**Consultation Response from KC,
Highways Development Management**

2025/91149 land at, Yew Tree Lane, Holmbridge, Holmfirth, HD9 2NR

Conversion of existing barn and outbuilding to form single dwelling, erection of new detached stables and implements store

Date Responded: 21/08/2025.

site plan as proposed  
Scale: 1:200

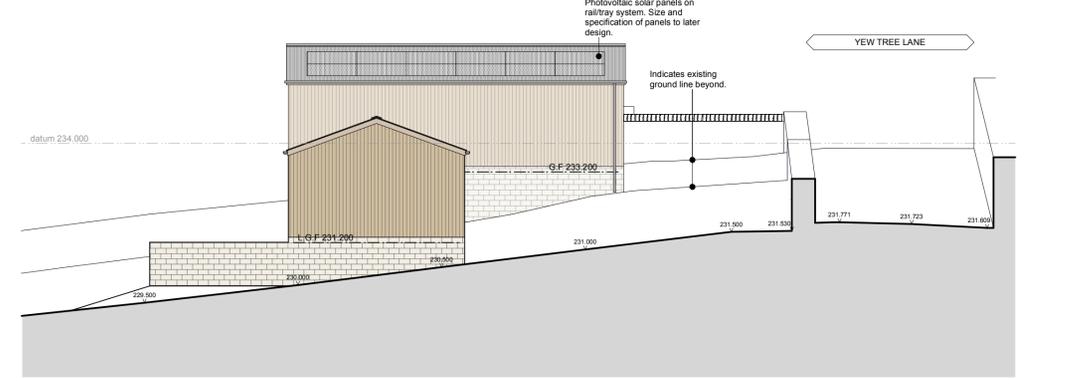
Two existing accesses to the site from Yew Tree Lane will be retained as part of the proposed scheme.

The lower vehicle entrance will provide access to the yard and parking to the dwelling, whilst the upper will be closed to vehicles and provide a pedestrian access to the front of the dwelling.

The existing double barn doors on the northeast elevation will be permanently closed and become a feature in the wall of the proposed dwelling.

The existing vehicle entrance is currently used by the applicant making 3 or 4 trips per day and the existing barn doors are used for regular deliveries. The barn doors open outward onto Yew Tree Lane obstructing the highway

Although the sightlines for the proposed vehicle access do not meet the required standard it is considered that the following mitigating circumstances will improve highway safety at this location and on balance the proposals are acceptable to Highways D M

- The existing upper vehicle access will be closed to vehicles
- The existing barn access will be closed
- The existing vehicle access is already in use by the Applicant and the proposal will not increase its use significantly

The proposal provides ample parking for the proposed dwelling, together with turning for vehicles to enter and leave the site in forward gear.

The approved vehicle parking areas will need to be surfaced and drained in accordance with the Communities and Local Government; and Environment Agencies 'Guidance on the permeable surfacing of front gardens (parking areas)' published 13th May 2009 (ISBN 9781409804864) as amended or superseded.
